## Response of Middle Aston Parish Meeting to Planning Application 20/01127/F

1. This application concerns the replacement of the eleven existing buildings at Hatch End Industrial Estate, in Middle Aston Parish, with thirty new units, increasing the floor area from 2297 square metres to 3198 square metres (39% increase). It is noted that the application is for B1 use, which is already permitted. There are currently 15 people regularly working at the site.

1 Proposed Section B-B
Scale: 1:100

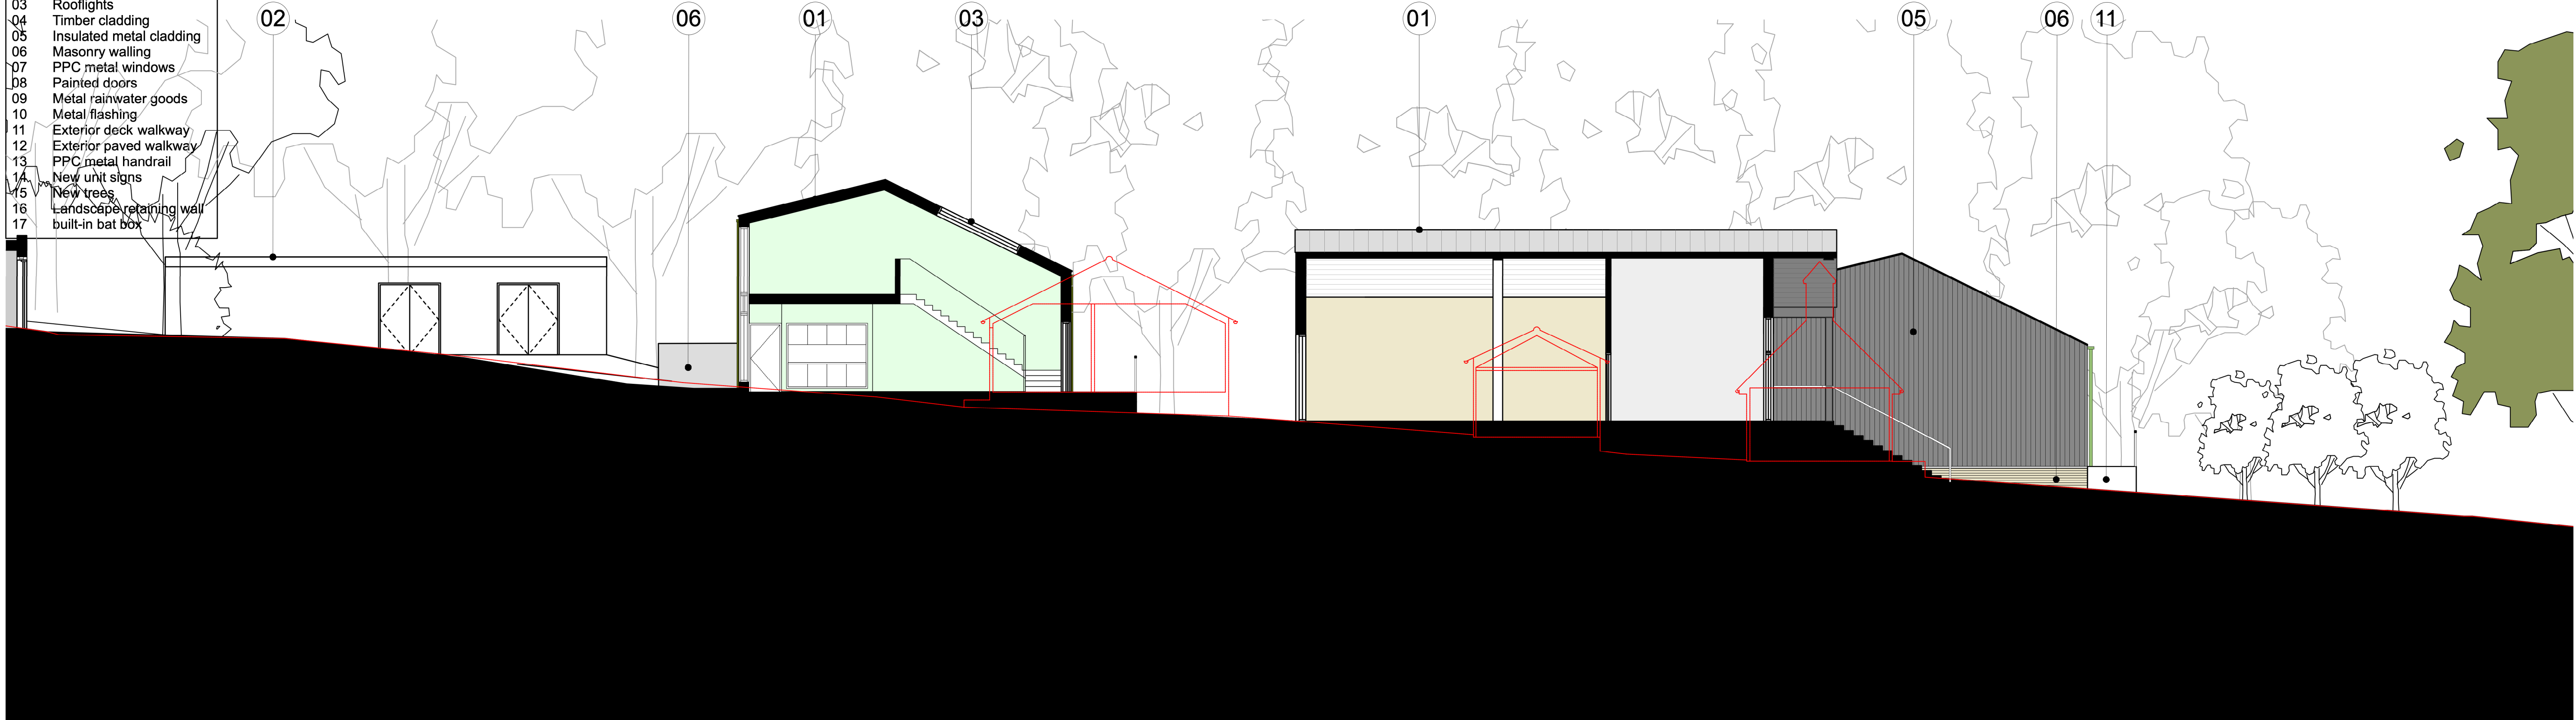
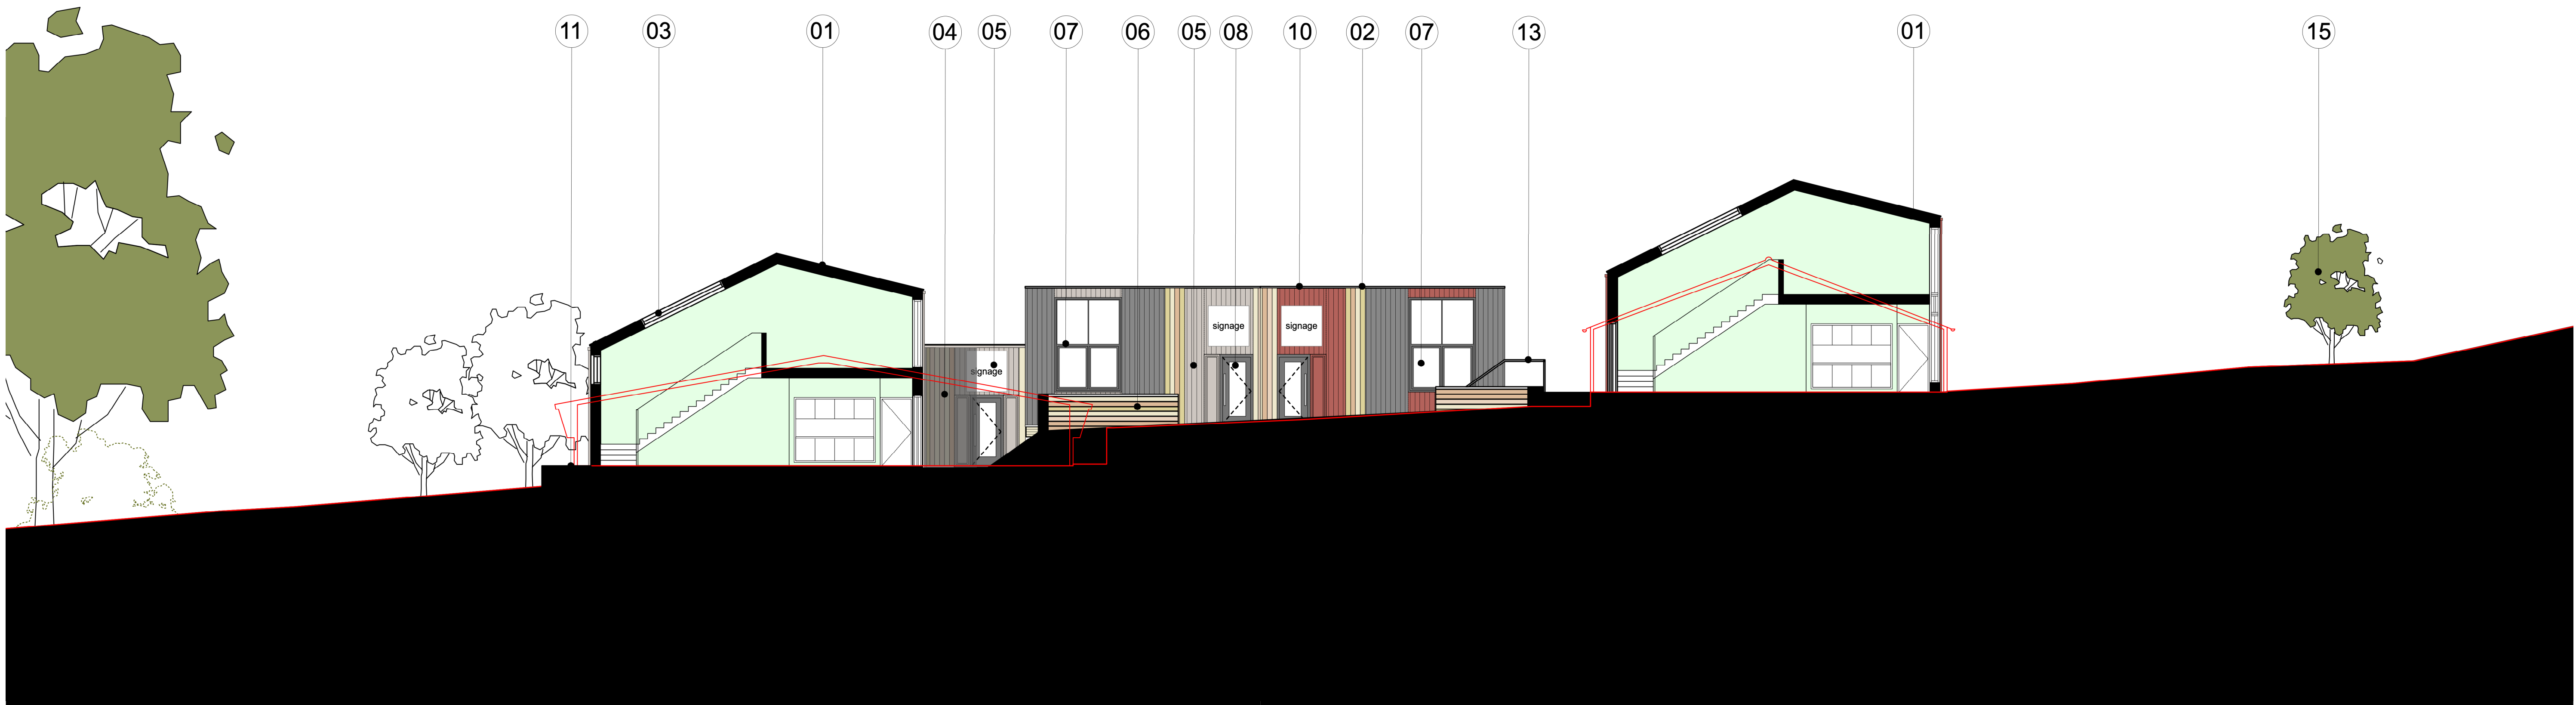
We consider that the proposal, by means of the mass, bulk and design of the proposed buildings, and the materials proposed for their construction, conflicts with these adopted policies. The

proposed buildings are up to 50% taller than those they replace and the urbanising effect of this will be particularly significant given the rising profile of the site away from the road towards the west.
